HINCKLEY NATIONAL RAIL FREIGHT INTERCHANGE

Appendix 2 - Response Report Sapcote Enhanced Scheme (LCC)

RESPONSE REPORT SAPCOTE ENHANCED
SCHEME

Report Title:	Hinckley National Rail Freight Interchange – Stage 1 RSA Response Report Sapcote Enhanced Scheme
Document Number:	HRF-BWB-HGN-RSA-RP-CH-0004
Prepared By:	BWB Consulting Ltd
Overseeing Organisation:	Leicestershire County Council
BWB Reference:	NTT2814

**SAPCOTE ENHANCED
SCHEME
VISIBILITY TO
PEDESTRIAN CROSSINGS**

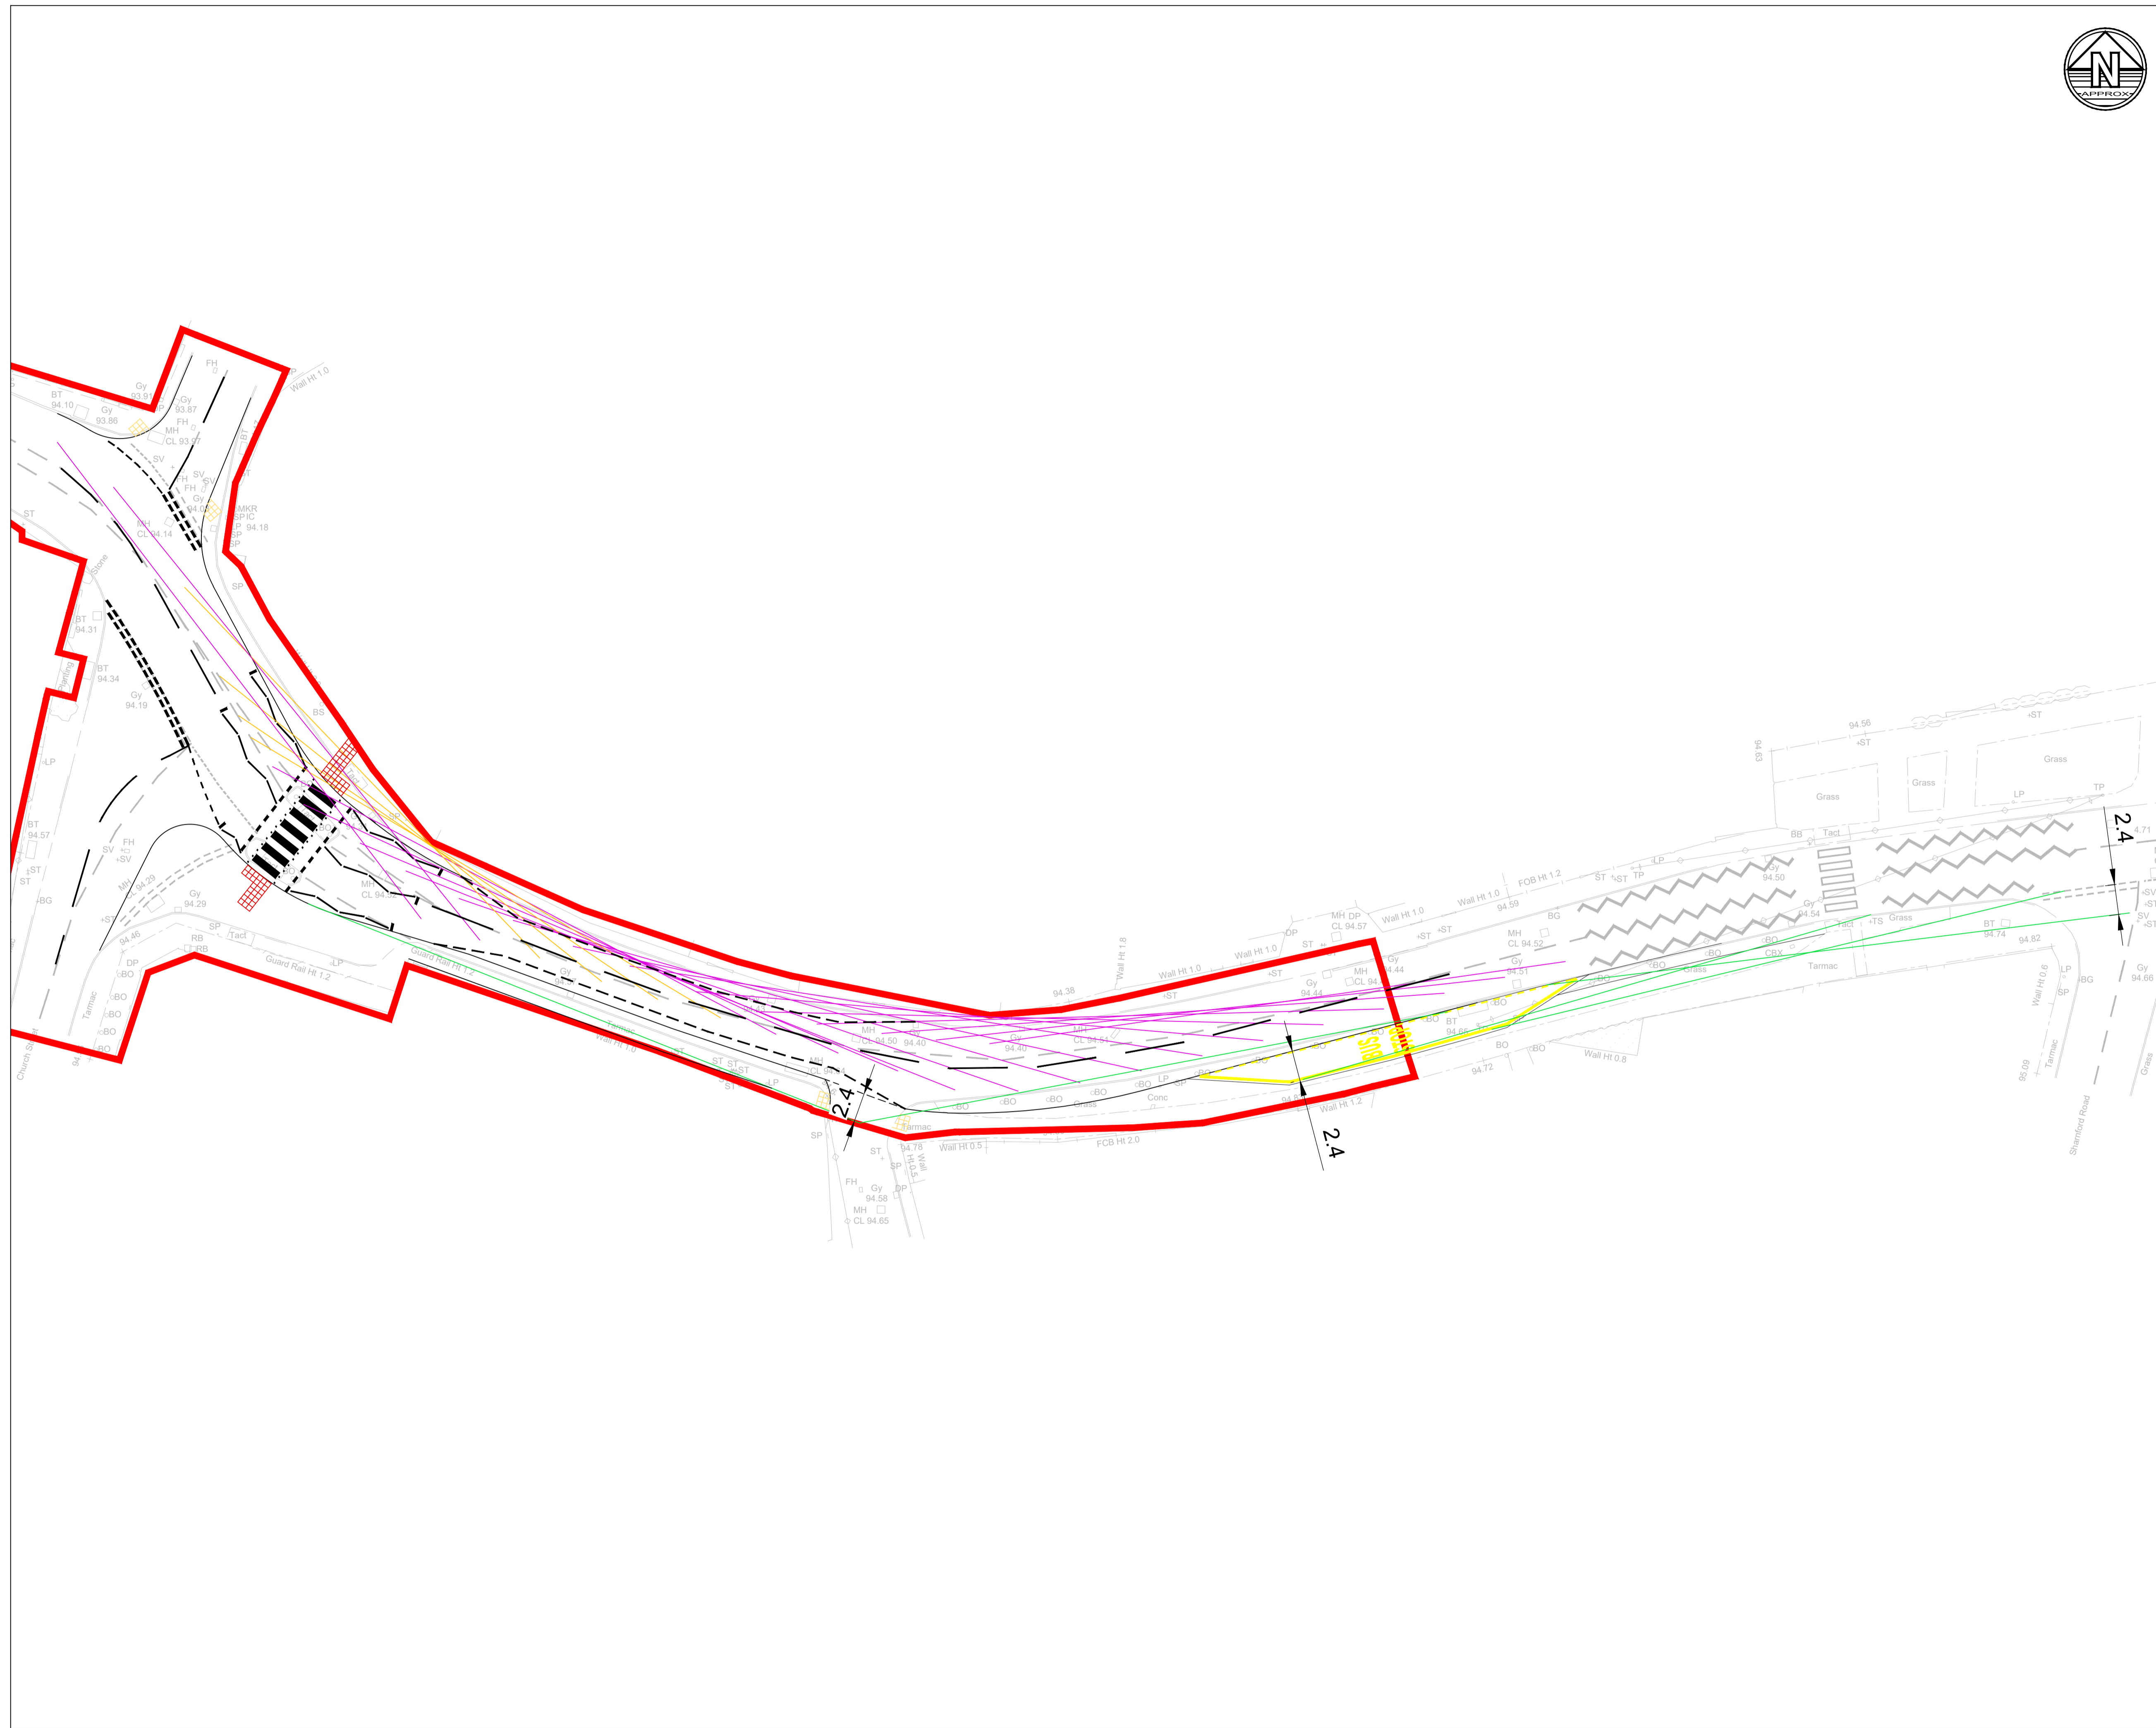
RSA Ref.	RSA Problem and Recommendation	Design organisation response	Overseeing Organisation Response	Agreed RSA action
	<p>Location: B4669 Hinckley Road - proposed pedestrian crossing to the west of the junction with Stanton Road.</p> <p>Summary: Restricted visibility risks vehicle to pedestrian collisions.</p> <p>Although visibility was available during the site visit, historical images show parking along the northern kerb outside of the Sapcote Club and adjacent properties that will limit visibility for and of pedestrians looking to cross north to south at the proposed pedestrian dropped crossing here. This risks pedestrians entering the carriageway into the path of an eastbound vehicle, resulting in vehicle to pedestrian collisions.</p> <p>Recommendation:</p> <p>It is recommended that, as part of the detailed design, waiting restrictions are provided to ensure that unobstructed visibility commensurate with approaching vehicle speeds is provided at the crossing.</p>	<p>Agree with RSA recommendation: Yes</p> <p>As part of the detailed design, waiting restrictions will be considered and provided through a TRO if agreed by the Overseeing Organisation and subject to appropriate consultation. A note has been added to the revised drawings.</p>	<p>LCC agree with the RSA recommendation in principle. However, a detailed parking accumulation survey is required to understand the level of parking that is taking place and when (days/hours/frequency/duration).</p> <p>An important consideration in the assessment of the implementation of any TRO will be where displaced parking could safely be located elsewhere on the network. This may require the introduction of additional measures e.g. formation of parking bays.</p> <p>It is also important to note that given the TRO does not form part of the DCO, this would be subject to a separate public consultation exercise with no guarantee of success. Any TRO and associated measures would be fully funded by the developer.</p>
